**19955 Wigwam Road, PPR-24-7**

Please accept the following comments from El Paso County Public Health (EPCPH) regarding the project referenced above:

Mike McCarthy  
El Paso County Public Health  
719-332-5771  
[mikemccarthy@elpasoco.com](mailto:mikemccarthy@elpasoco.com)  
10May2024

DESIGNED BY: JO
DRAWN BY: JO
CHECKED BY: AS-BUILTS BY: CHECKED BY:

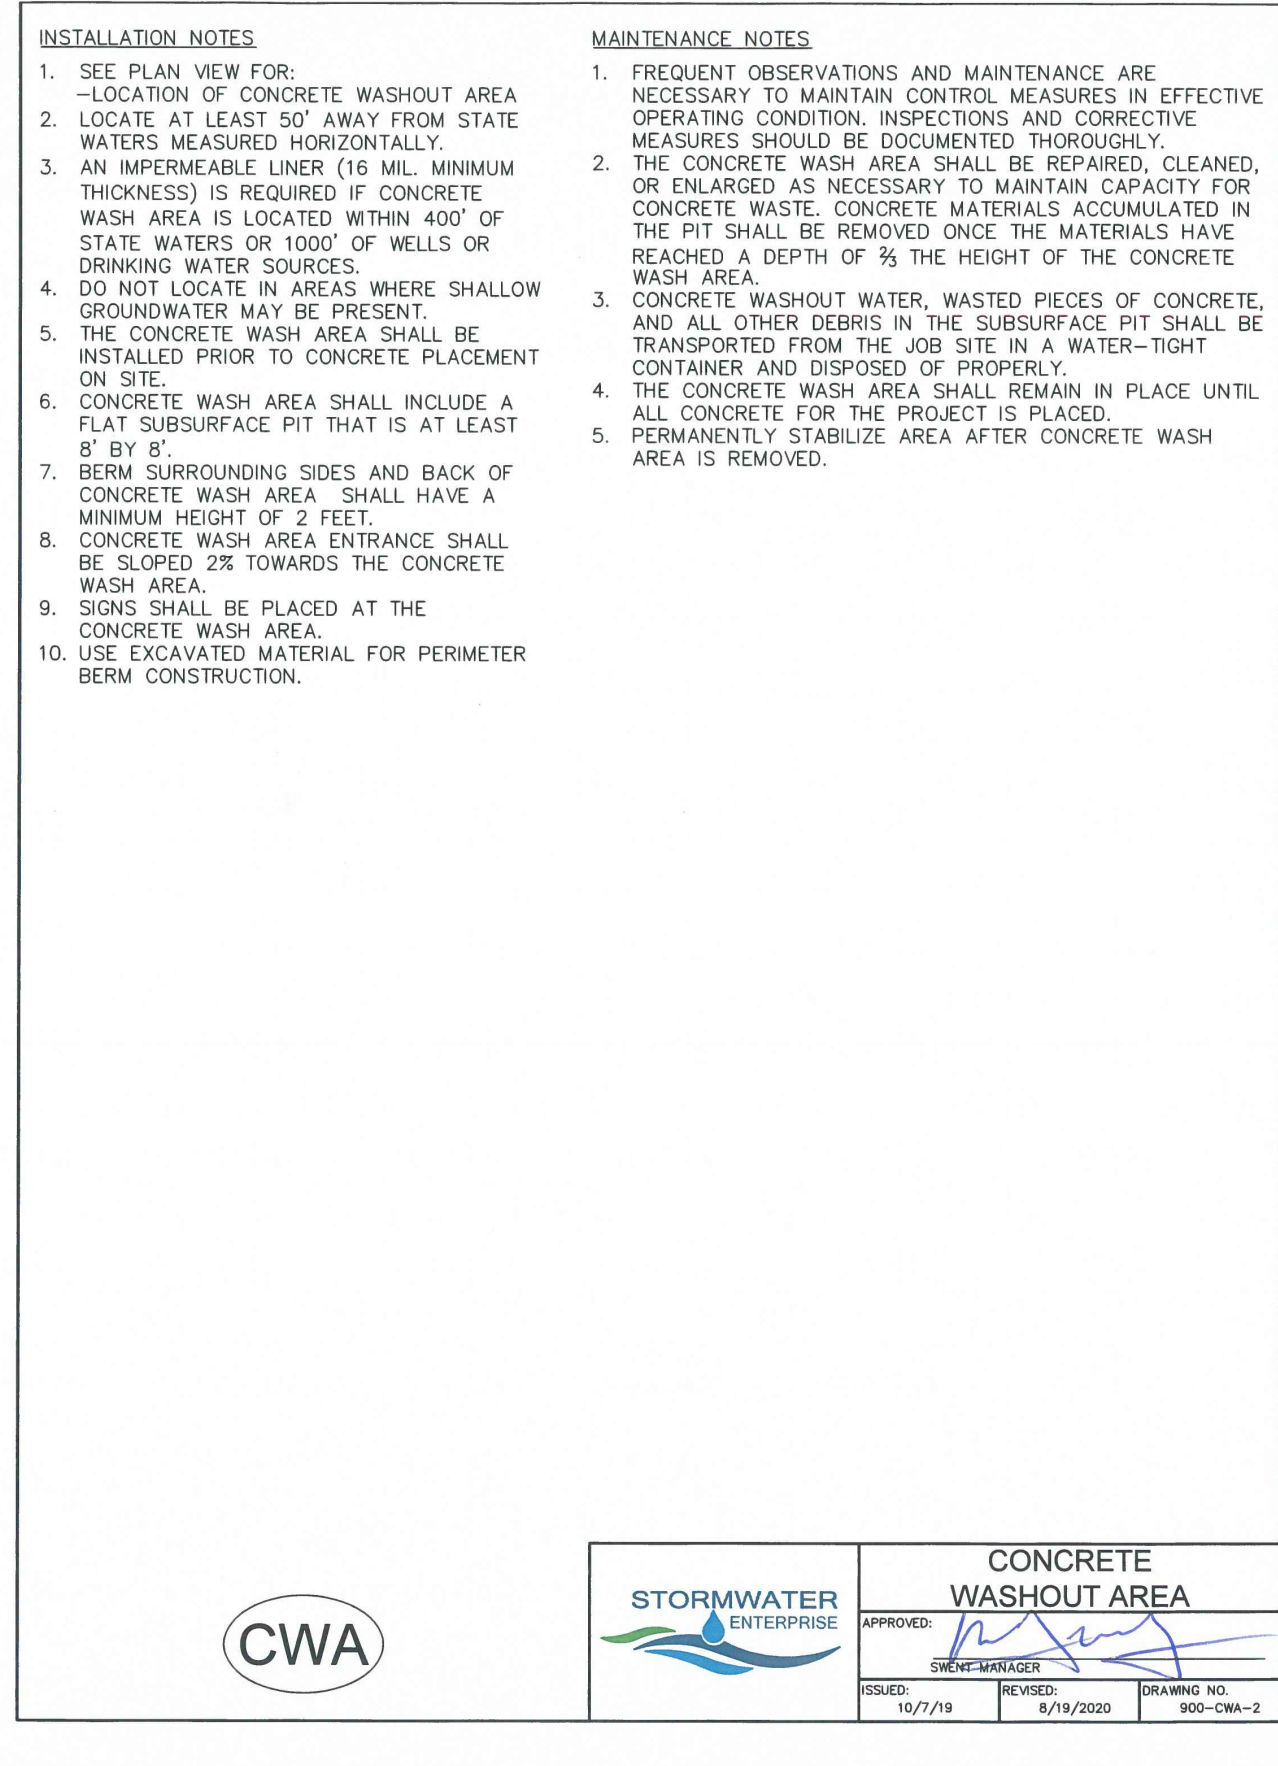
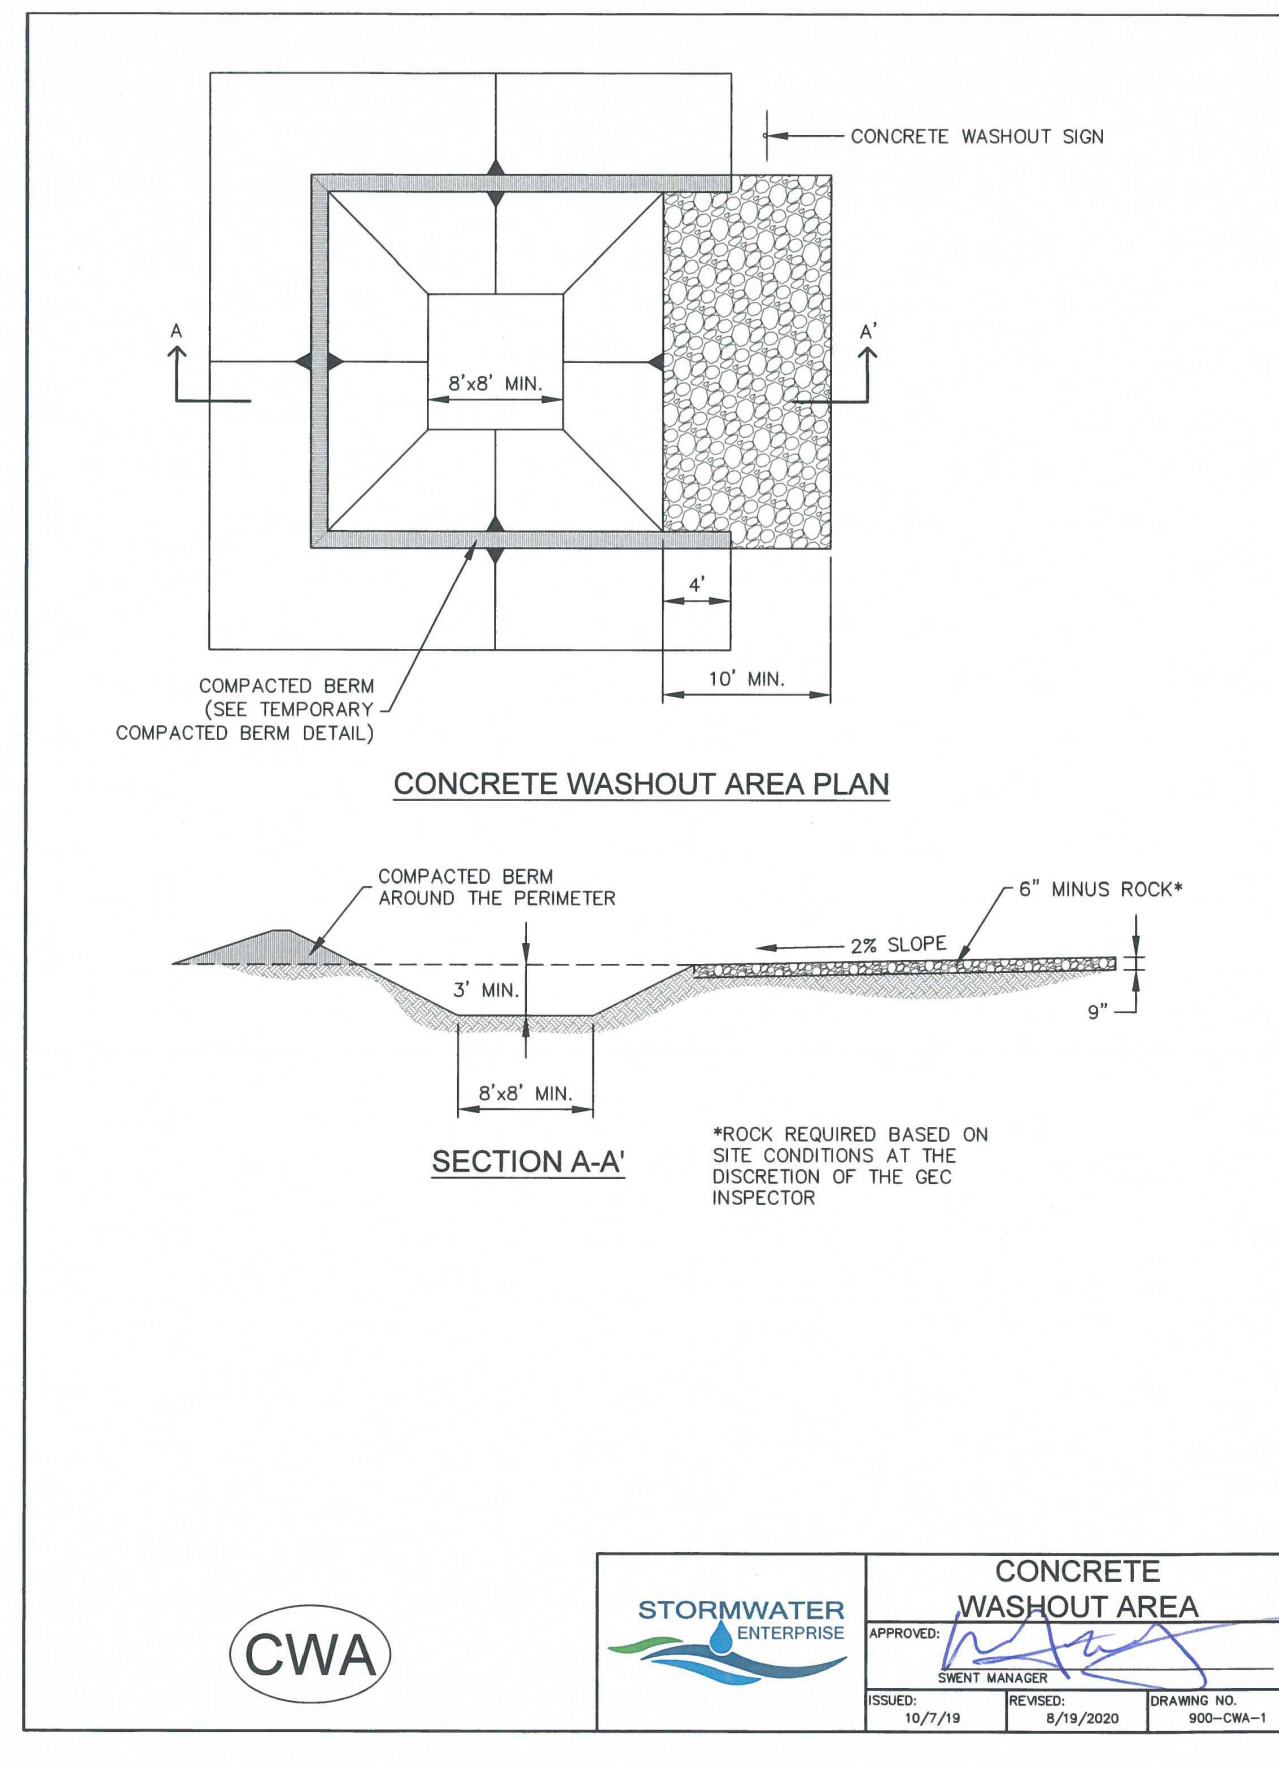
- Earthmoving activity in excess of one acre, but less than twenty-five acres, requires a local Construction Activity Permit from El Paso County Public Health. Go to <https://www.elpasocountyhealth.org/service/air-quality/construction-activity-application> for more information.
